Recommendation Report for Planning Permission for Works or Extension to a Dwelling

REF NO: M/72/21/HH

LOCATION: 7 Tuscan Avenue
Middleton-On-Sea
PO22 7TE

PROPOSAL: Erection of single storey side extension following demolition of existing garage.

DRAWING No
348/01

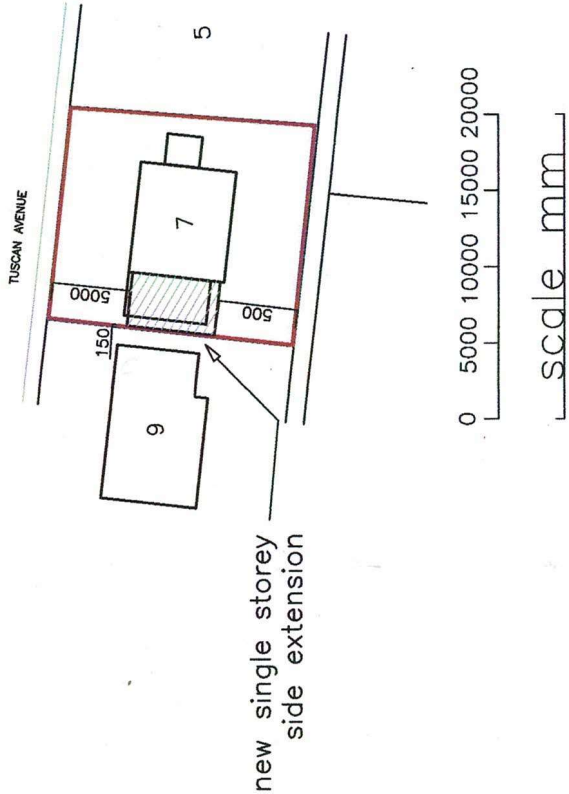
The loss of a garage space could lead to an additional on street demand. However there appears to be sufficient on curtilage land for two car in accordance with the Arun Parking SPD.

DRAWING
**PROPOSED
PLANS**
DRAWING No
348/03
SCALE 1:100
DATE MARCH 2021

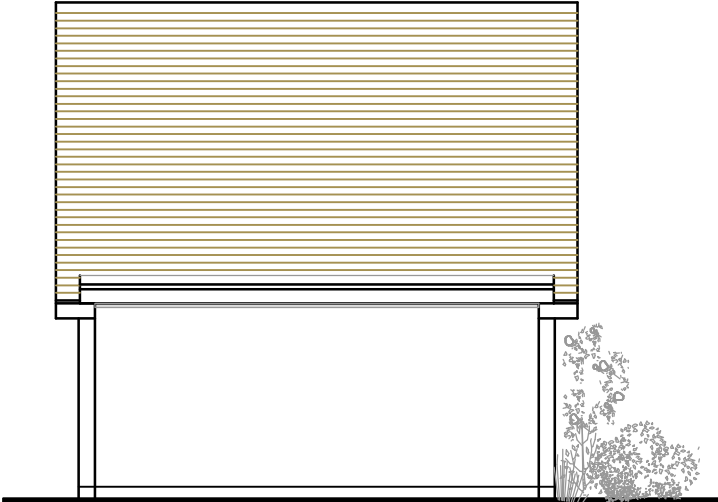
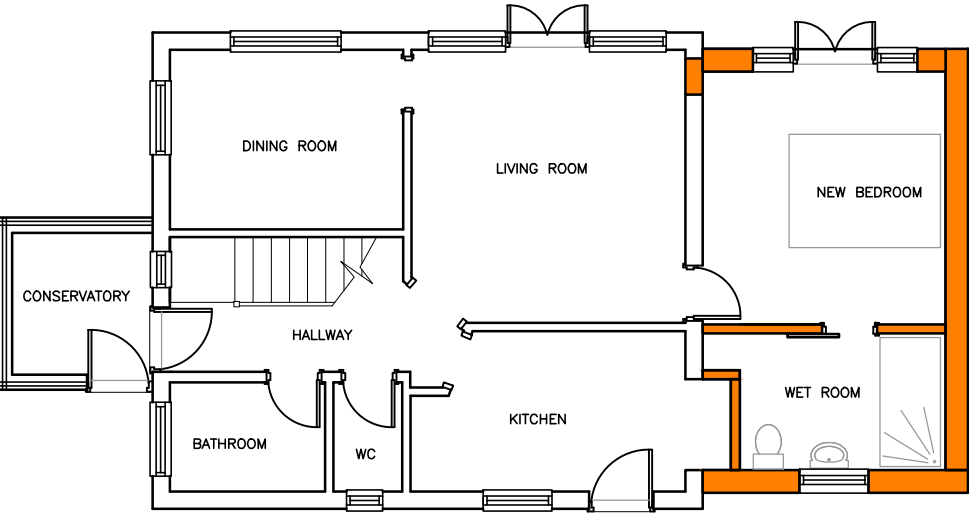
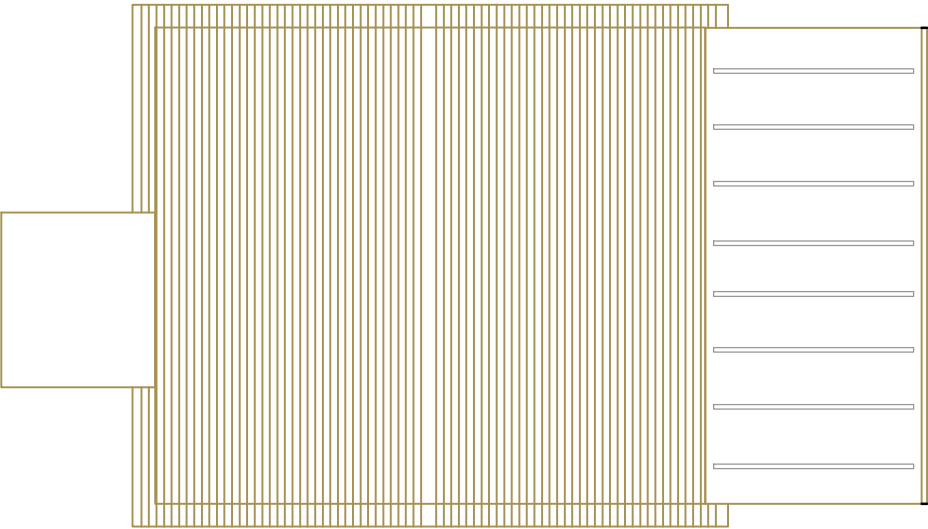
This application proposes the erection of a single storey side extension following demolition of the garage. The extension would be built on the similar footprint of the existing garage. Overall the extension would blend in within the architectural composition and appears subordinate to the main house. Arun's Design Guide suggest side extensions should be set back and the gap from the boundary should be maintained. However in this case, it is single storey addition and proposal would have lesser impact on the street scene; therefore it considered to be acceptable. Similar extension could be built under the provisions of permitted development. Materials of the extension would match the host dwelling. The development accords with D DM1 and D DM4 of the Arun Local Plan.

In relation to the adjoining dwellings, the extension would be built on a similar footprint to the garage; Therefore it would not alter the existing situation. No windows have been proposed in the side elevation and no overlooking would occur.

The extension does not beyond the side elevation therefore no significant impact in terms of overbearing or loss of light. Overall the development is not considered to harm neighbouring amenity by way of overbearing, overshadowing or overlooking and accord with D DM1 and D DM4 of the Arun Local Plan.
